**FOR AN ORDER GRANTING DEVELOPMENT CONSENT  
FOR THE SEA LINK PROJECT**

**(REF: EN020026)**

**DEADLINE 7: PORT OF LONDON  
AUTHORITY'S COMMENTS ON SUBMISSIONS  
RECEIVED AT DEADLINE 6**

Plate 3.1 Cable route overview showing key infrastructure, cable crossings, water depths, and vessel density

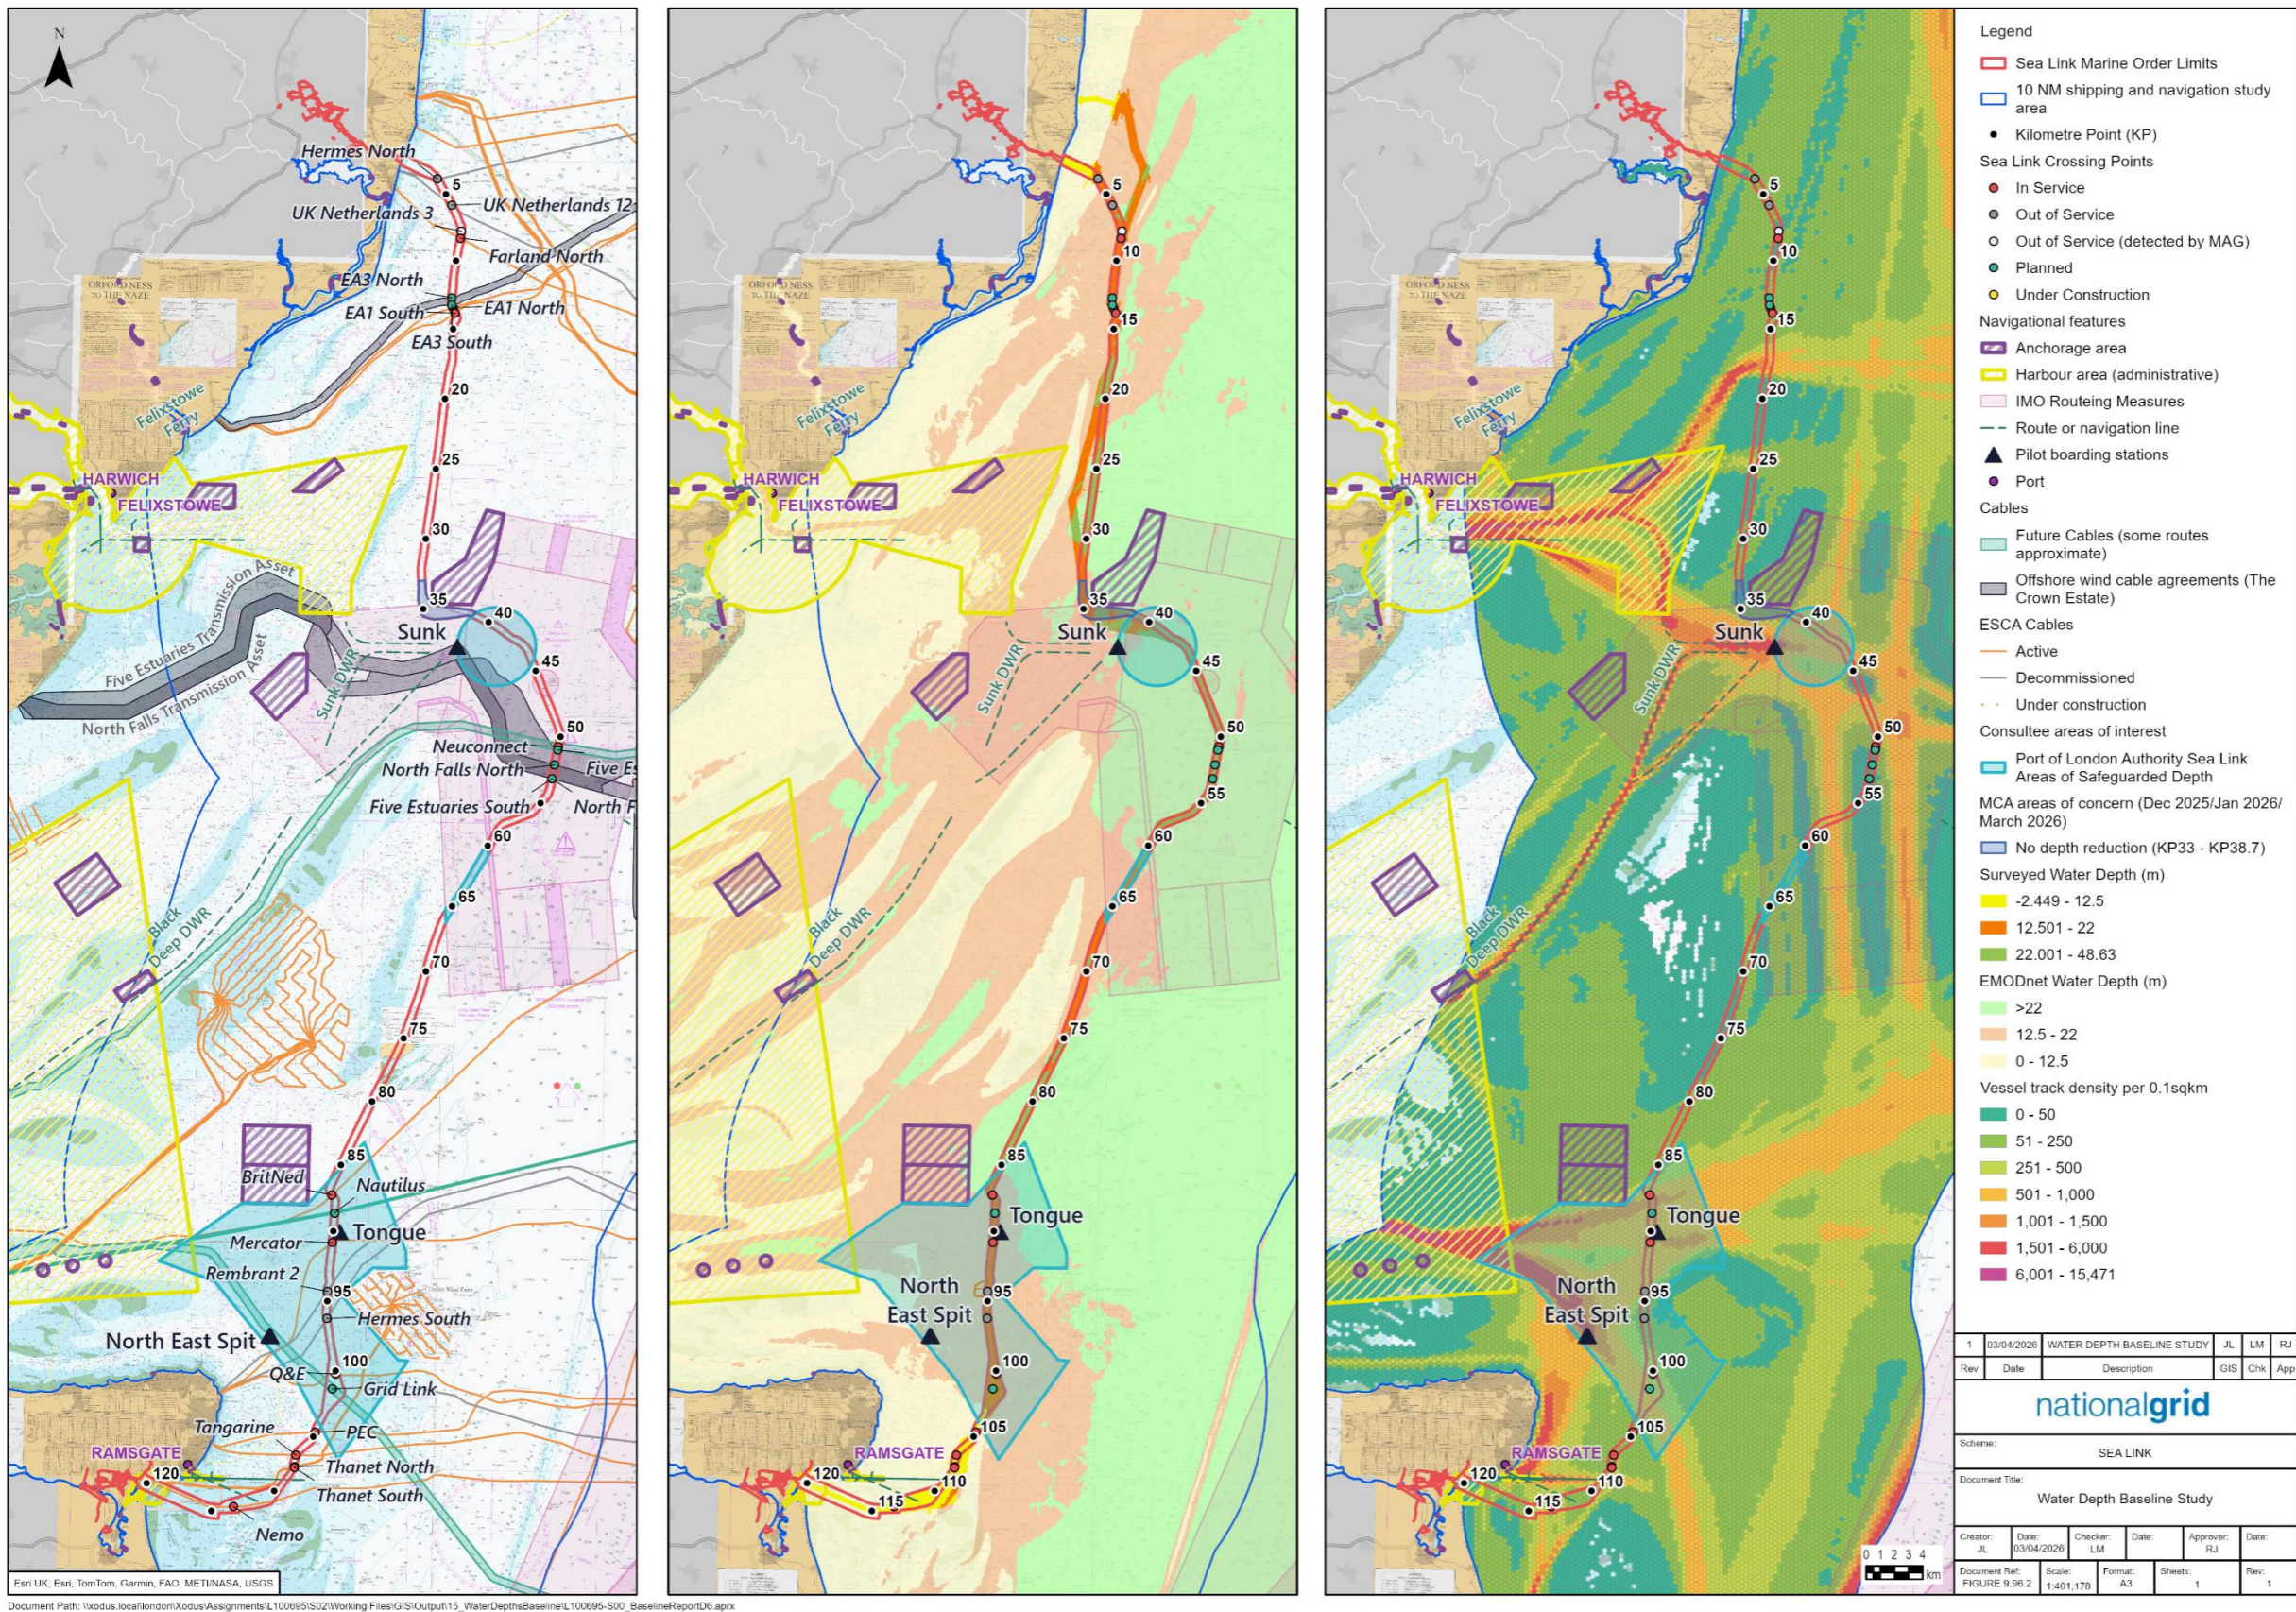
7.2 The PLA remains of the opinion that concurrent RAM activity should also be prohibited in the North East Spit and that this should be made clear in the oNIP and shown on plate 3.1.
